Recommendation Report for Planning Permission for Works or Extension to a Dwelling

REF NO: A/186/25/HH

LOCATION: 16 Speedwell Chase
Angmering
BN16 4QR

PROPOSAL: Conversion of garage into habitable space.

SITE PLAN
1:500 @ A3

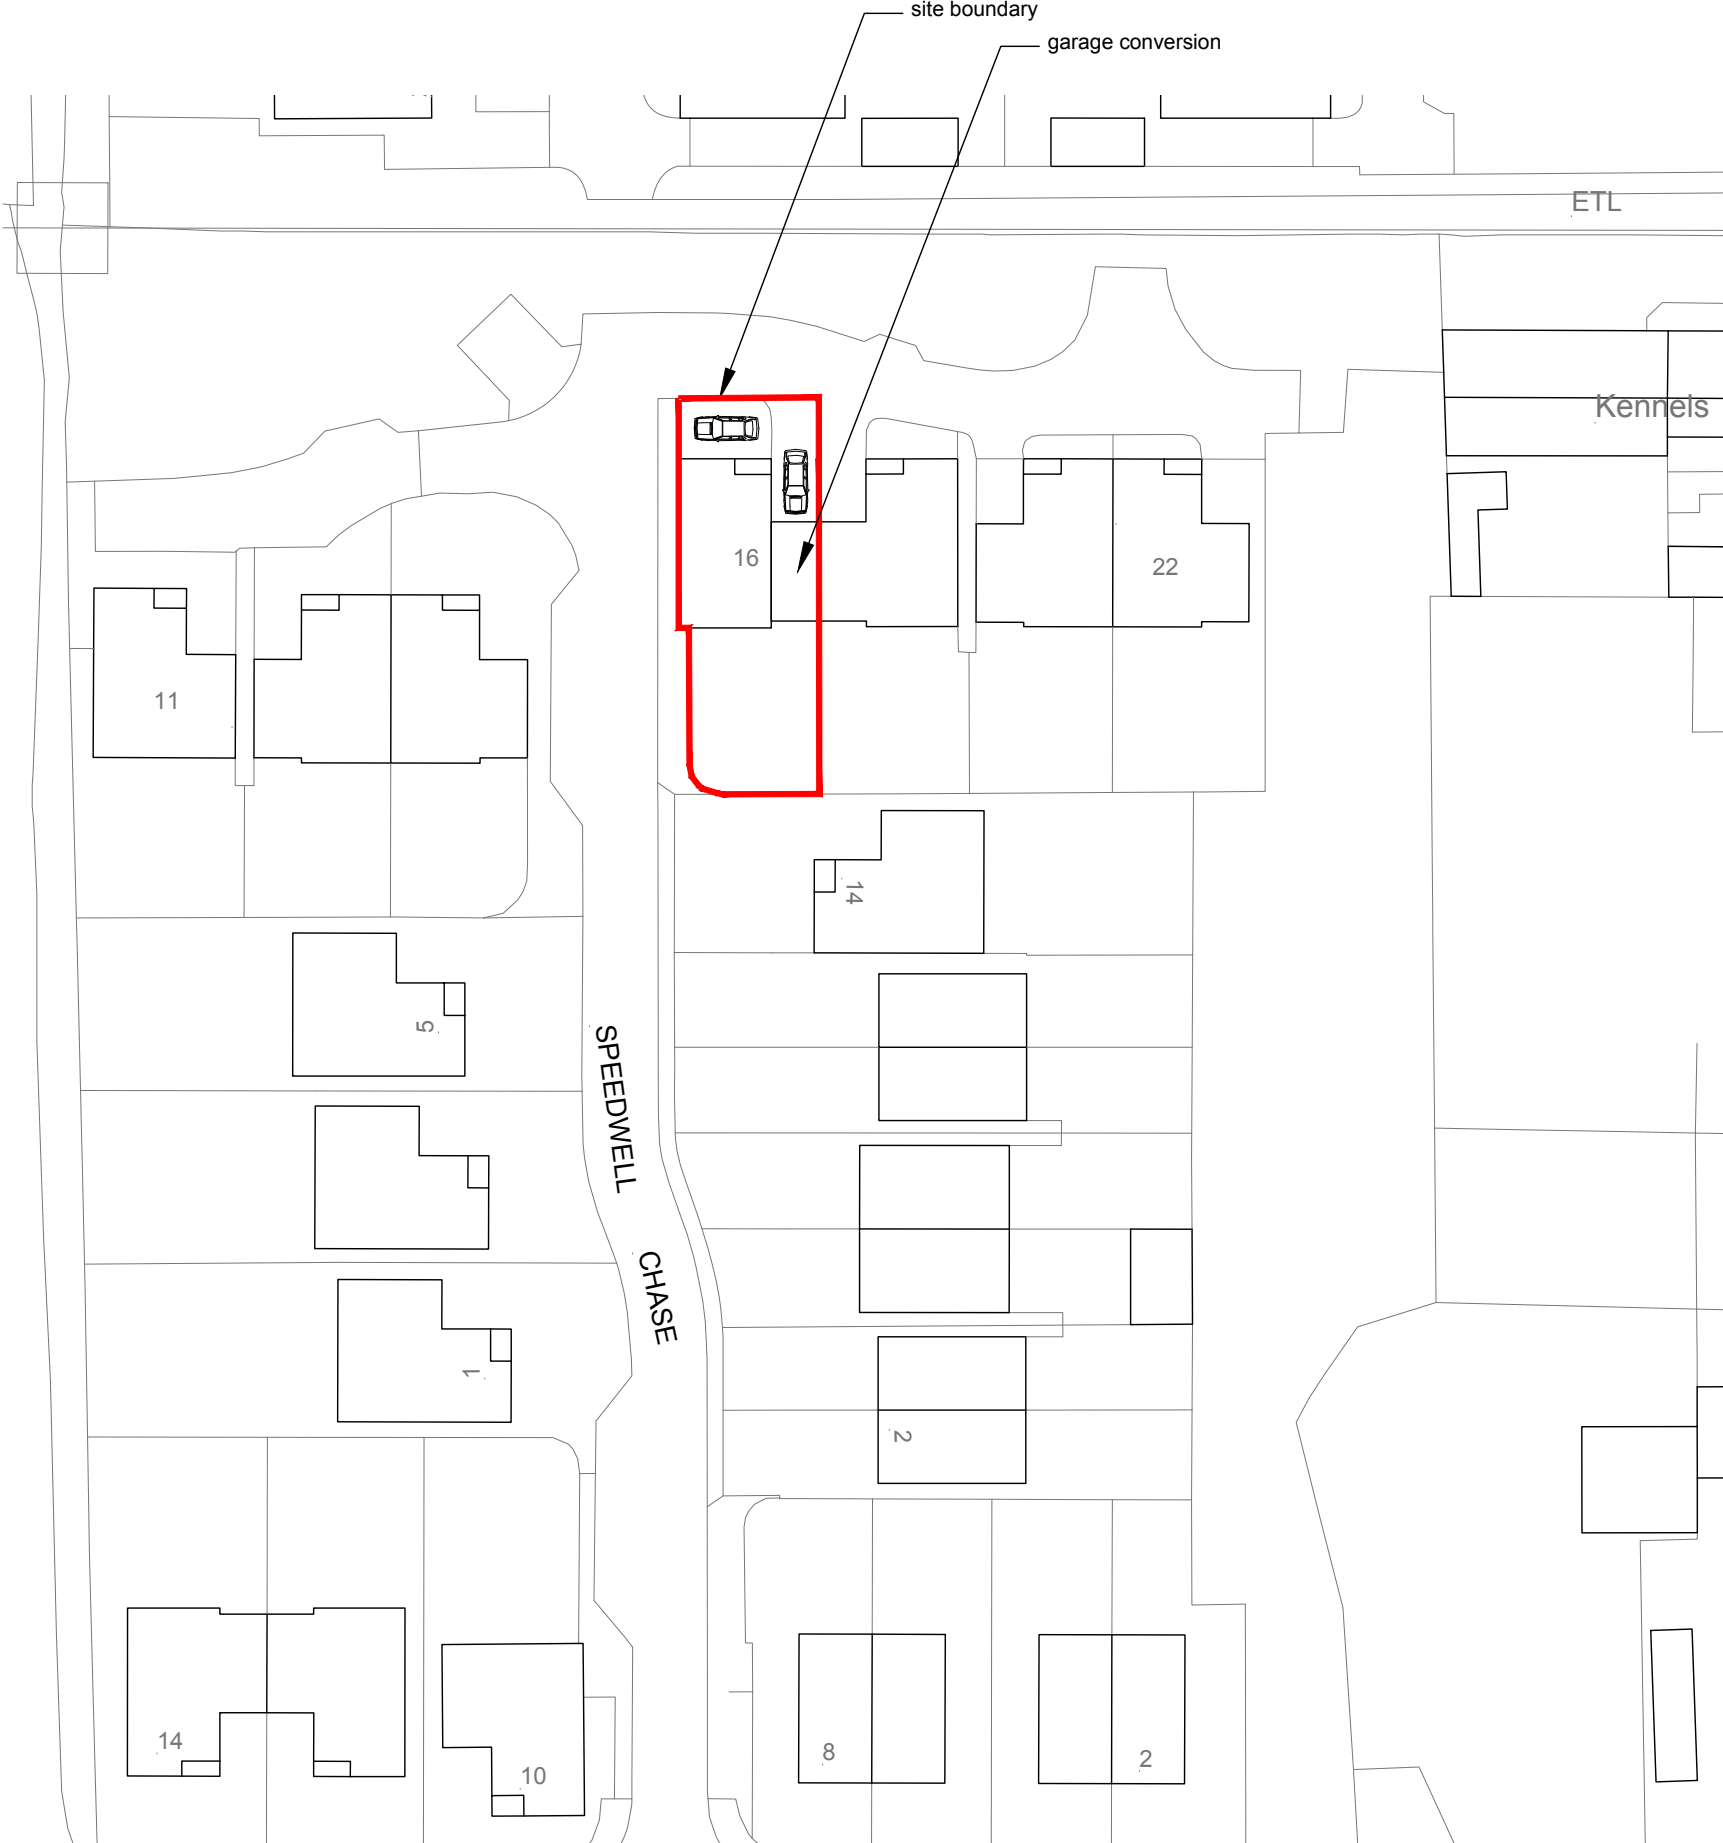
The Proposed Site Plan submitted with this application proposes two parking spots, one immediately adjacent to the existing garage and one new space outside of the front of the dwelling, running parallel to the front elevation, but retained within the site boundary. The parking spaces proposed under this application would comply with ADG guidance for standard parking spaces (a minimum of 5m by 2.5m).

It is acknowledged that the parking space proposed to the front of the dwelling does not follow the pattern of the parking layout throughout Speedwell Chase, however, any harm to amenity would be isolated to the host dwelling and would not be unduly harmful. Furthermore, it is noted that the area to the front of the host dwelling has already been paved, thus could already accommodate a vehicle. The proposal would protect the interests of the condition attached to A/46/19/PL, ensuring that there would be provision for the accommodation of vehicles clear of the highway, in accordance with Arun Local Plan policies D DM1 and T SP1.

Rev.	Notes	Date
 M: 07599199759 E: info@nat-design.co.uk www.nat-design.co.uk		
Project		
16 Speedwell Chase, Angmering, BN16 4QR		
Drawing		
Existing & Proposed Floor Plans		
Drawn By		Scale
NSE		as shown
Date		Revision
Nov 2025		
Drawing No.		
2018 - DPA - 03

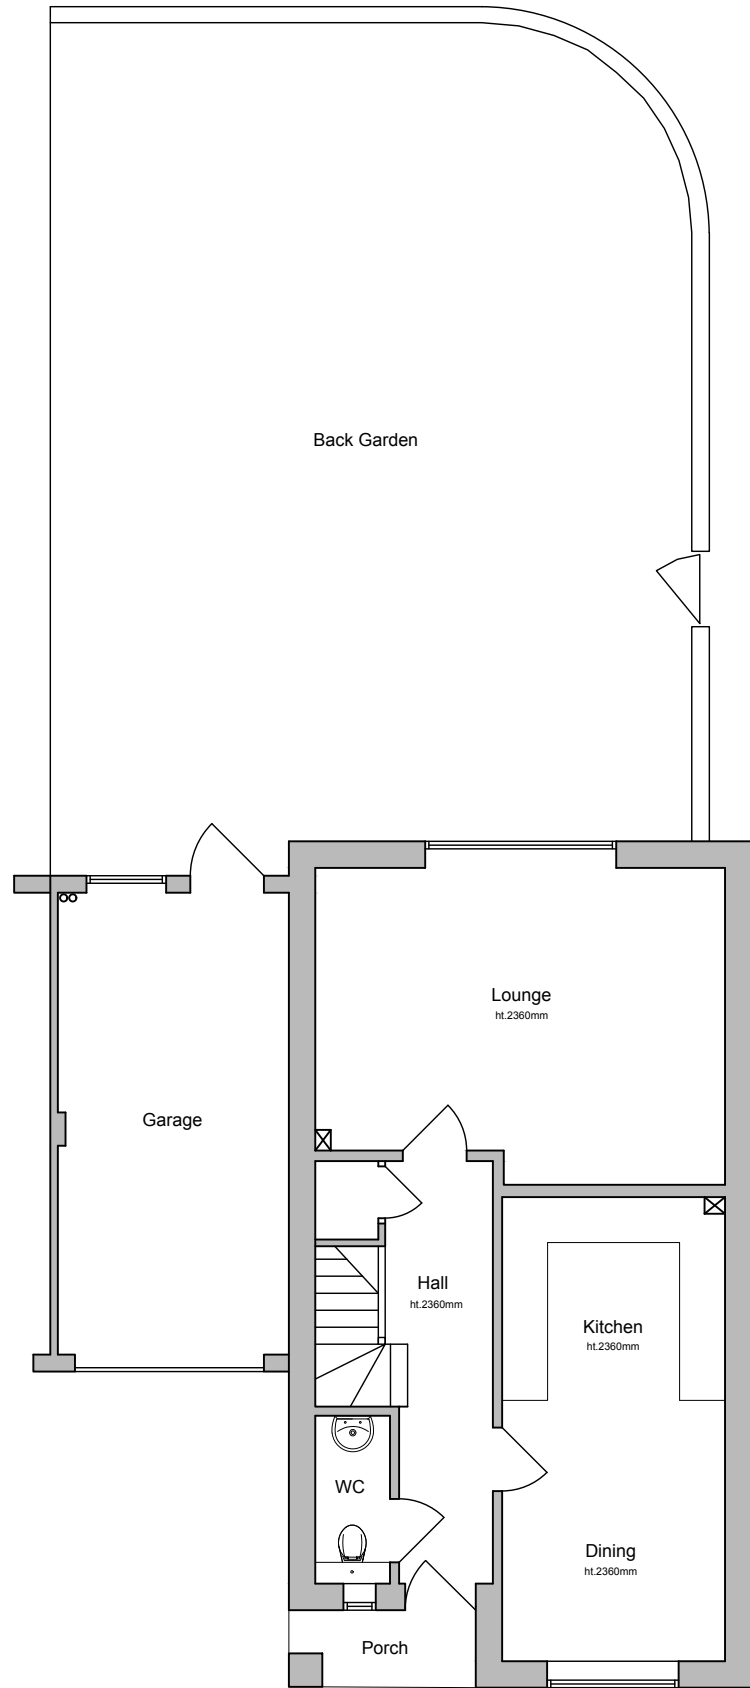
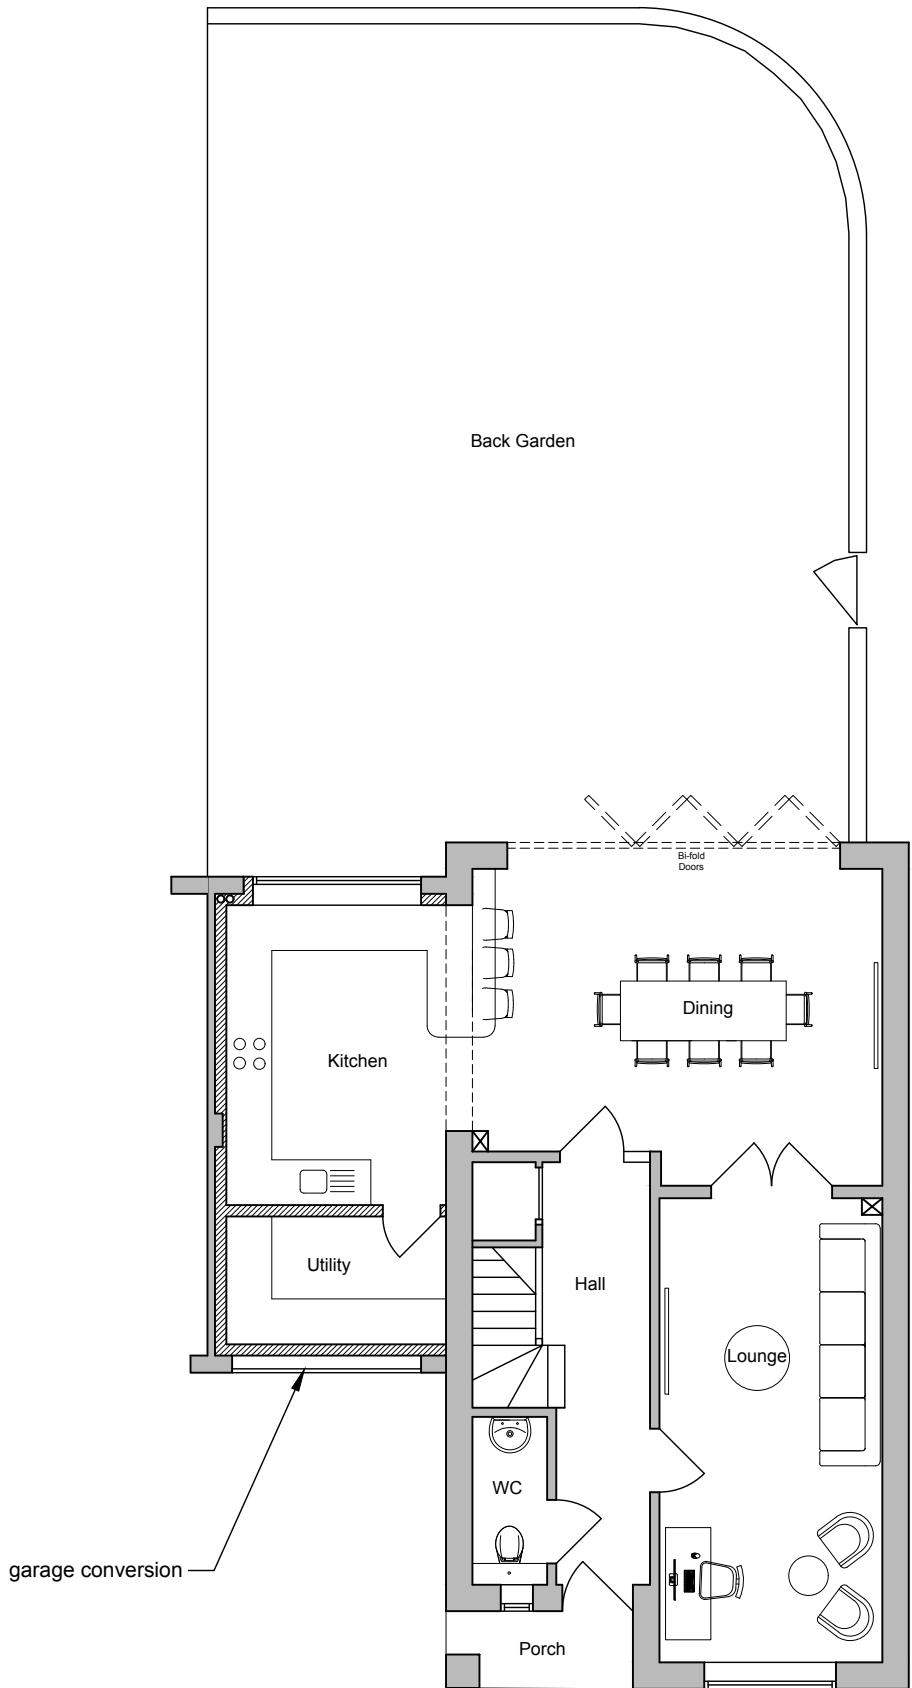
The site is a semi-detached dwelling on Speedwell Chase. The application seeks permission for a garage conversion to facilitate an amended ground floor layout including amended fenestration on the rear elevation.

The garage conversion would not increase the massing or bulk of the host dwelling; the only changes to design would be on the rear elevation, where the door and small window that serve the existing garage would be replaced by a larger window and the existing double doors which would be replaced by larger bi-fold doors.

South Elev Scale 1:100 @ A3

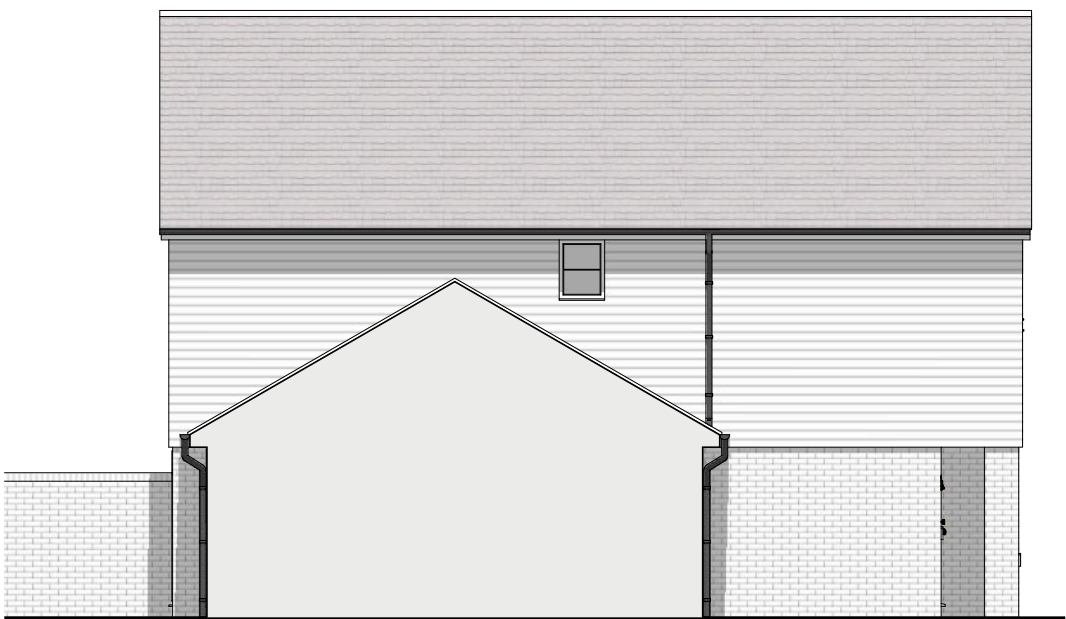
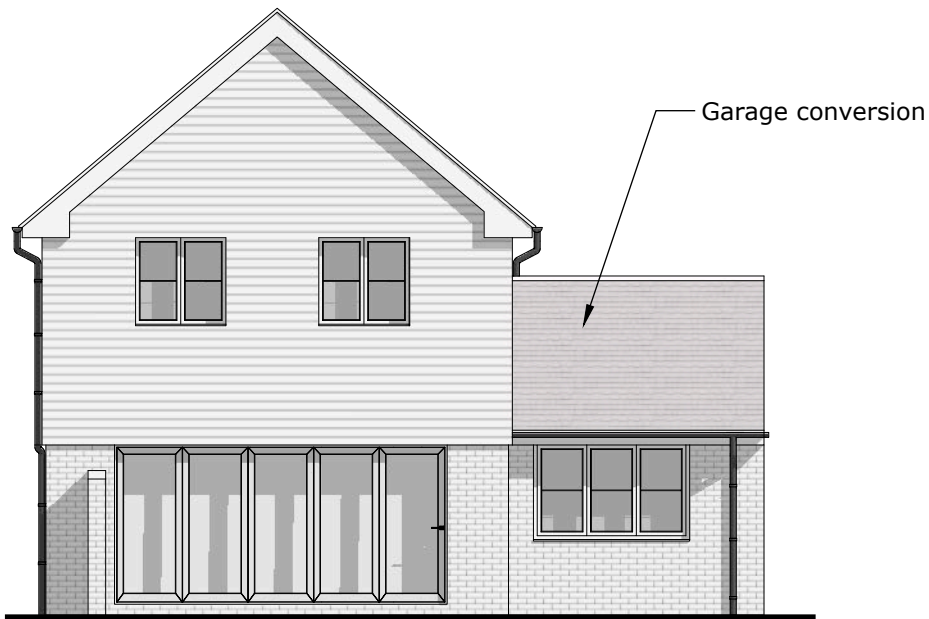
The proposal would not impact the character of the host dwelling; the amended fenestration would be a

minor alteration and would not result in harm to design or visual amenity, in accordance with Arun Local Plan policies D DM1 and D DM4.

The amended fenestration would be at ground floor level, located similarly to the windows and doors currently in situ. No outlook would be achieved from these windows or doors that could not be achieved from the existing windows or rear garden. Therefore, there would be no harm to residential amenity by way of overlooking.
